September 24, 2026

Re: Professional Engineer's Certification of Permanent Control Measure
Flying Horse North Filing No. 4, Pond B

This letter serves as a Pond Certification for the constructed Full Spectrum Detention Facility "Pond B" located in Flying Horse North Filing No. 4. The permanent control measure is located at the north central area of the subdivision and the northwestern part of the filing, adjacent and north of Old Stagecoach Road.

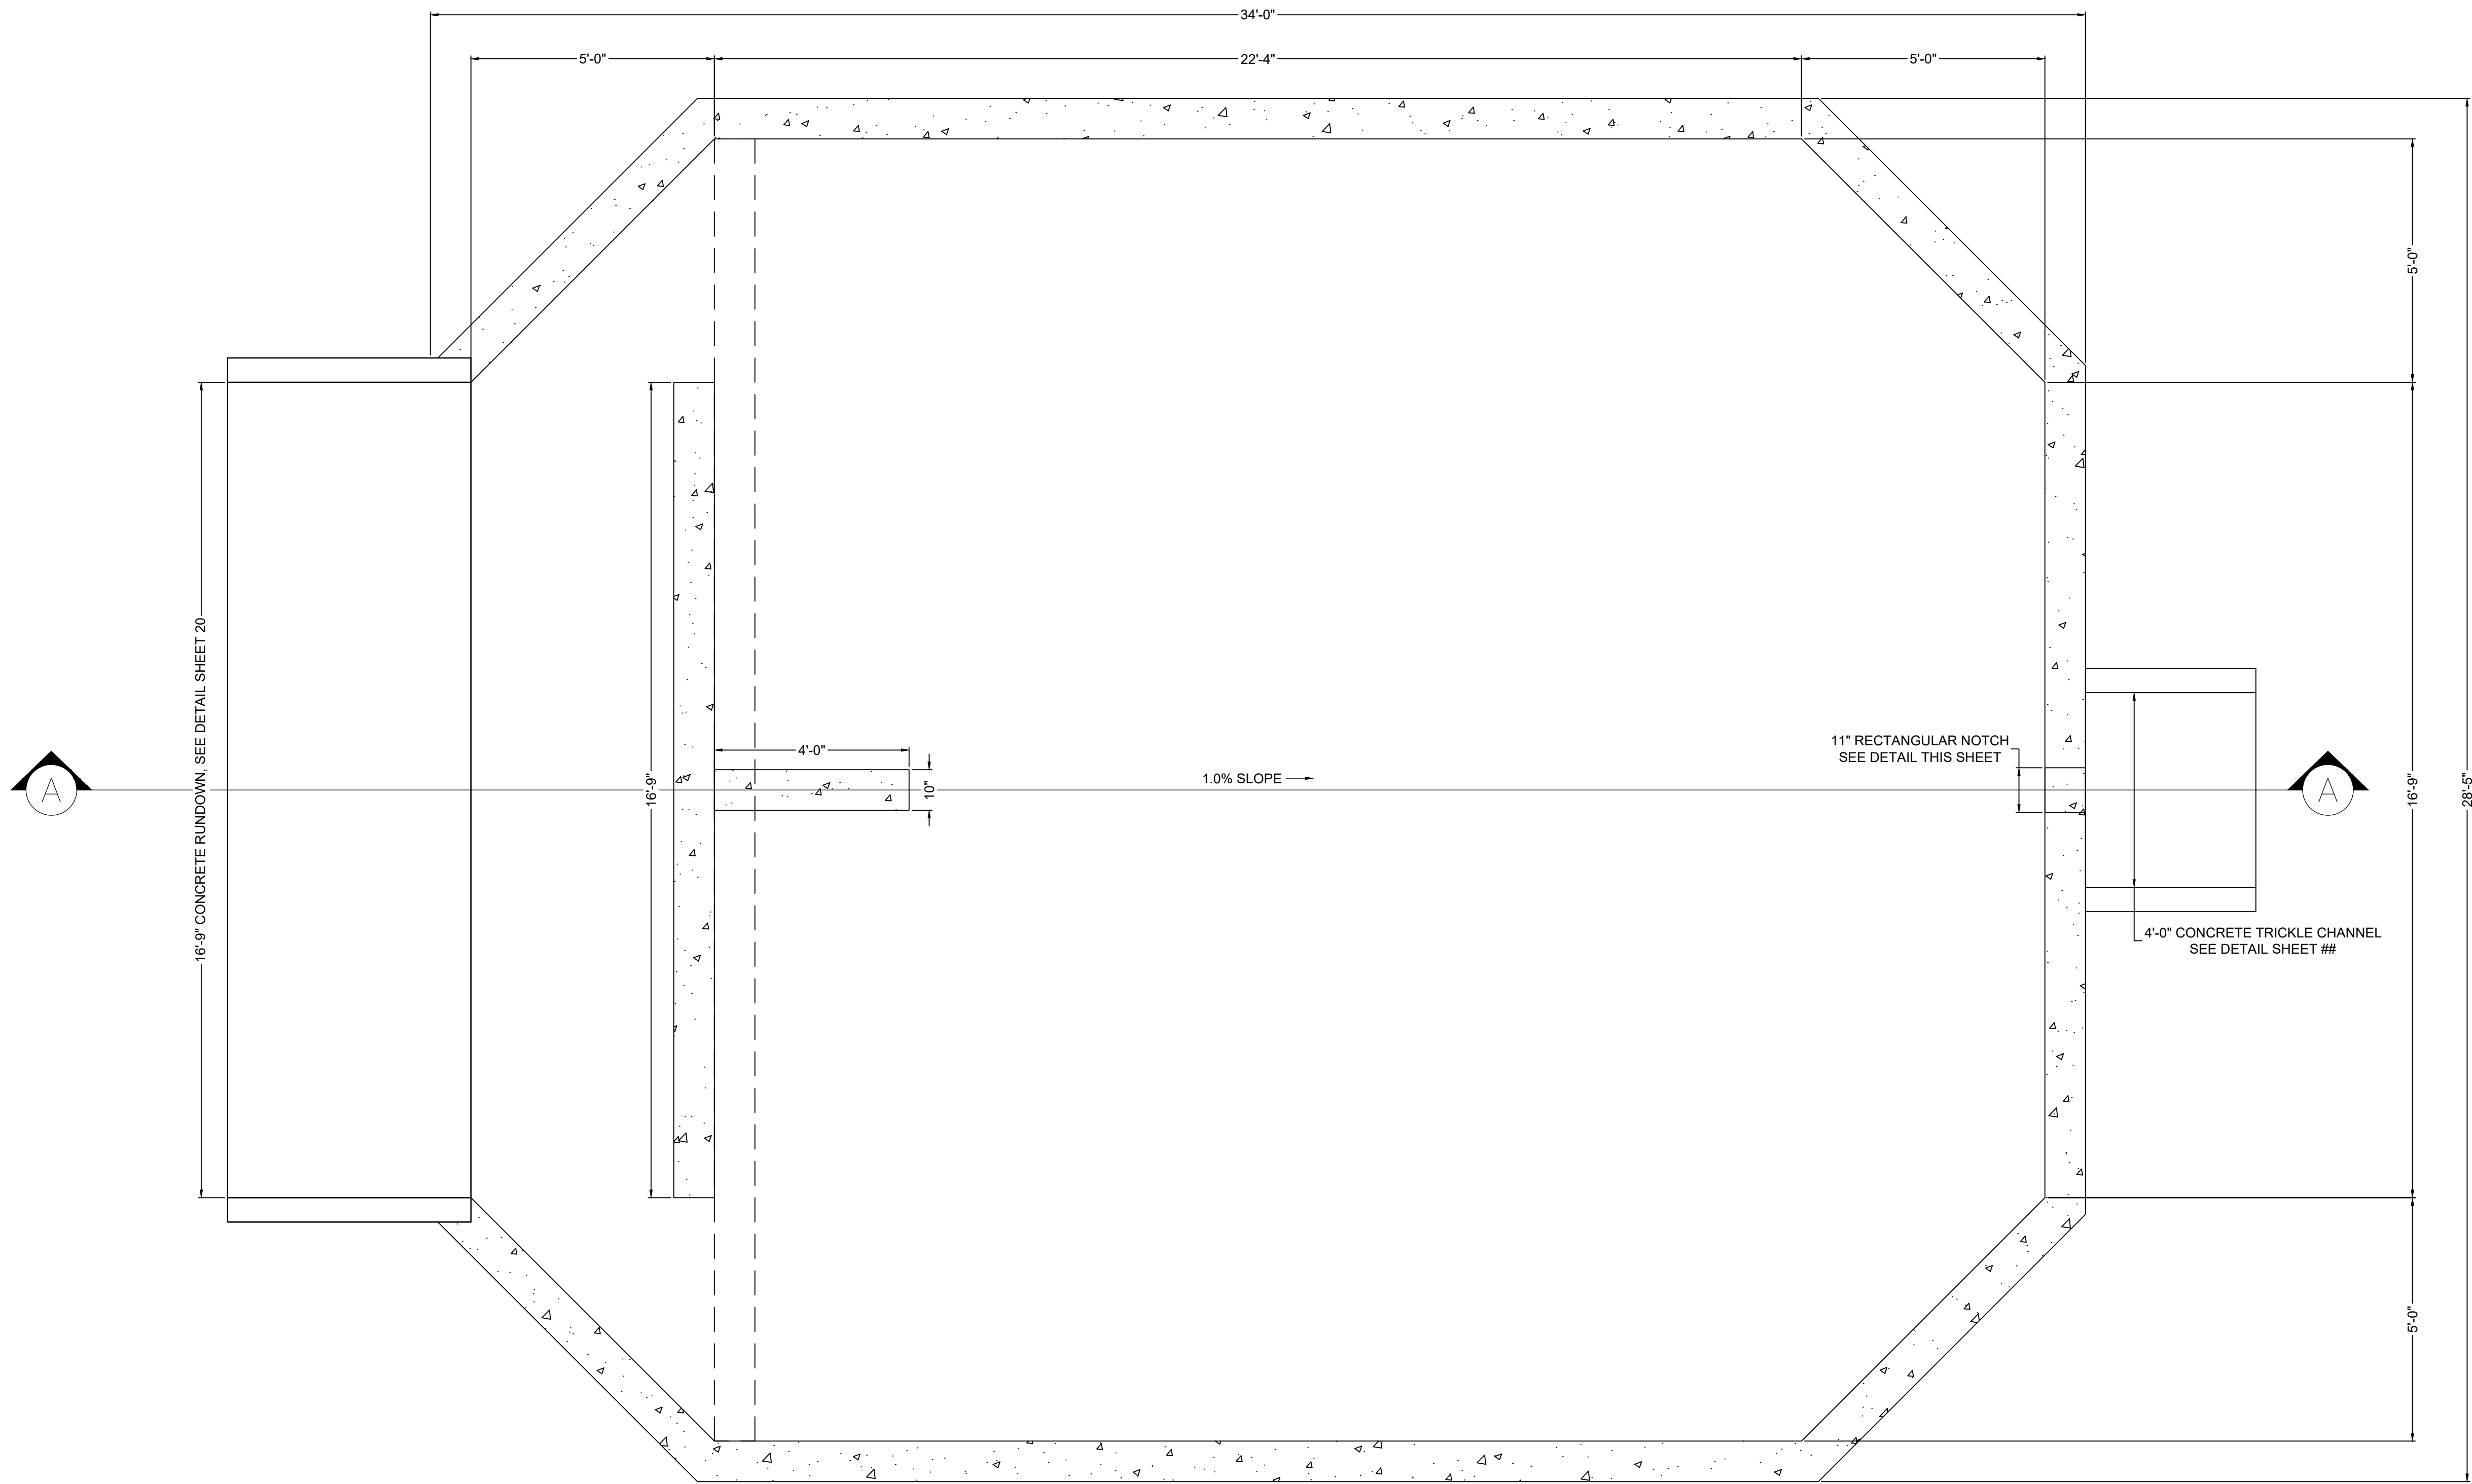
Im not seeing a vertical orifice on the as-built CDs (note that there was one on original design CDs though). Am I missing something? It's not on the orifice plate detail, so I don't know where else it would be.
